## **Application by National Grid Electricity Transmission Limited for an order granting development consent for the Sea Link project**

### **Planning Act 2008 – Section 89**

### **The Infrastructure Planning (Examination Procedure) Rules 2010 – rule 17**

The Examining Authority (ExA) writes to the parties listed above, under rule 17 of the Infrastructure Planning (Examination Procedure) Rules 2010, following deadline (DL) 6 on Monday 13 April 2026. The ExA requests the following additional information and clarifications to be submitted by **DL7, Wednesday 29 April 2026**.

Viewpoint 6 (a): Public Footpath (Friston 260, route 17), east of Sternfield, looking southeast

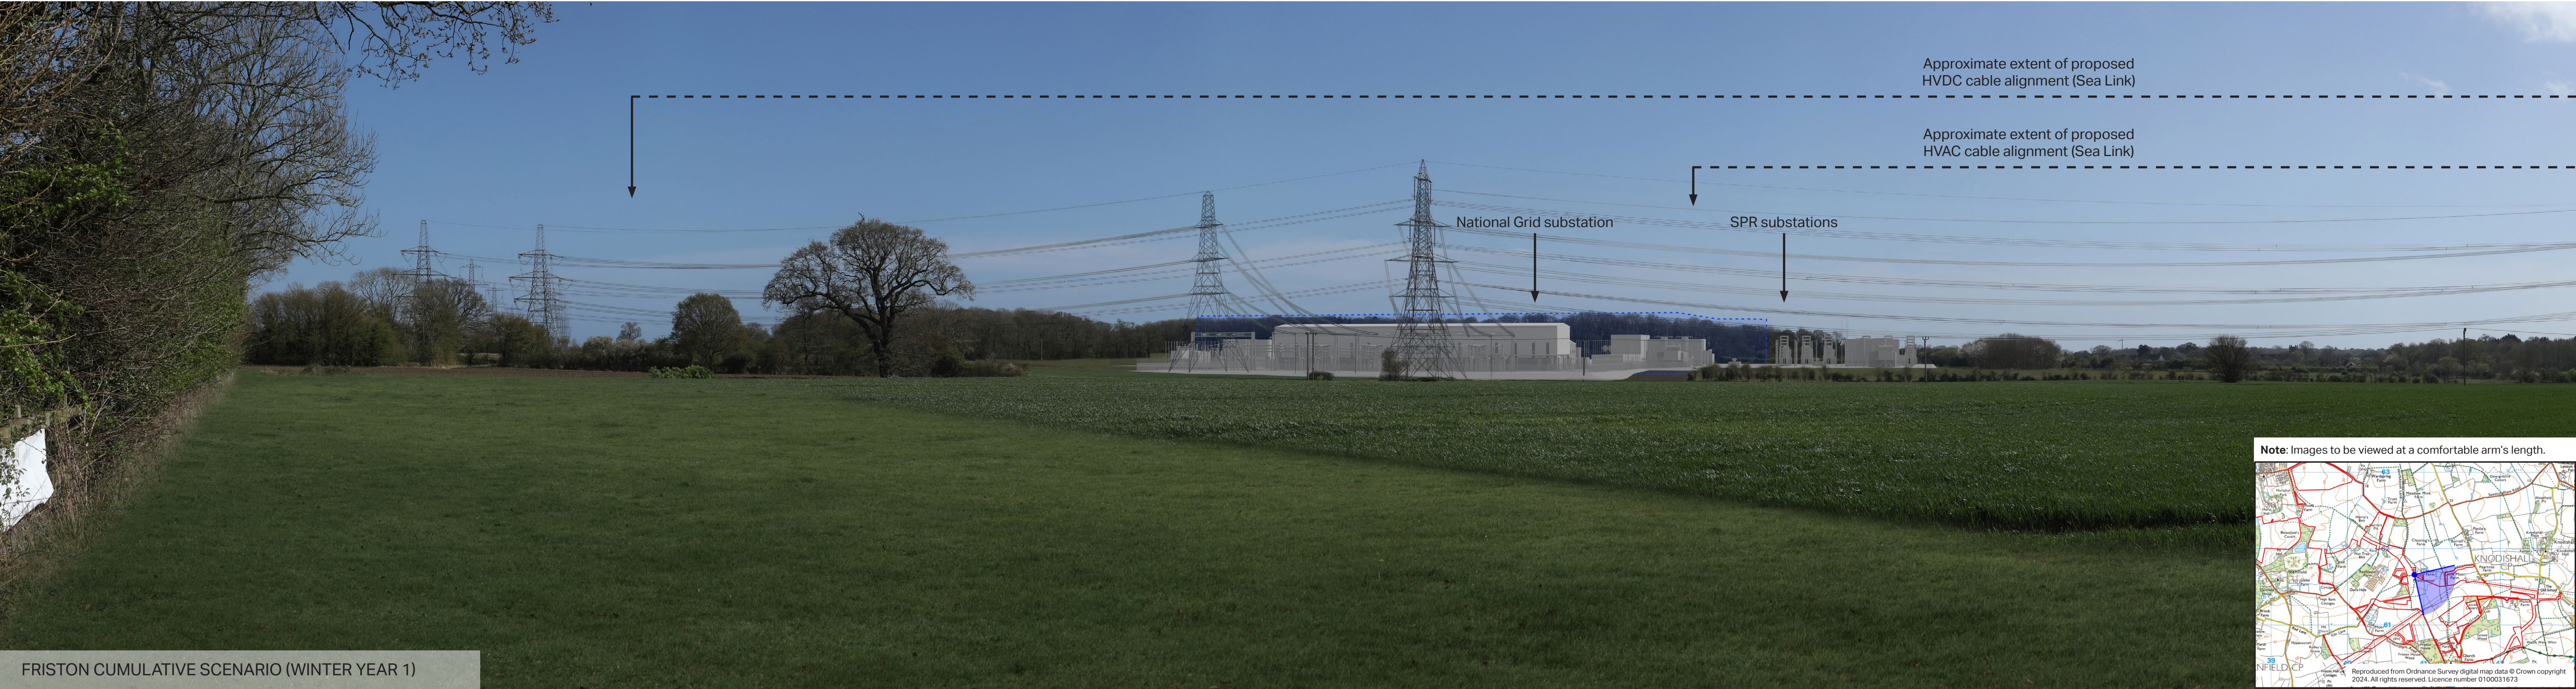
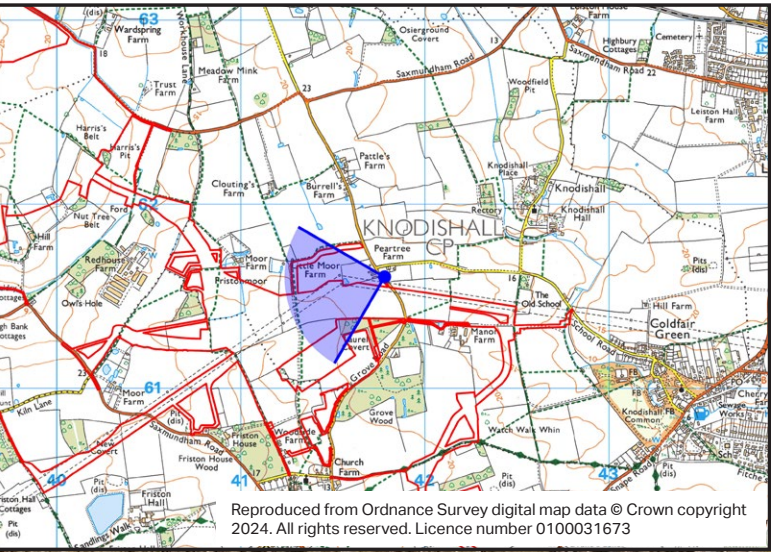
The ExA notes that the applicant's response [REP4-086] to AP50 [EV6-033] included an updated outline landscape mitigation plan to reflect the submitted SPR landscape mitigation. Furthermore, an updated figure D-1 was provided in appendix B of [REP4-086] showing the additional interface with LionLink. When compared with the oLEMP as originally submitted [APP-348] it appears that planting to the south of High House Farm has changed from being native woodland and tree planting to just tree planting in the latest version of the oLEMP [REP6-078]. The applicant is requested to clarify whether the proposed planting has been reduced and whether the visualisation for viewpoint 6a is still accurate.
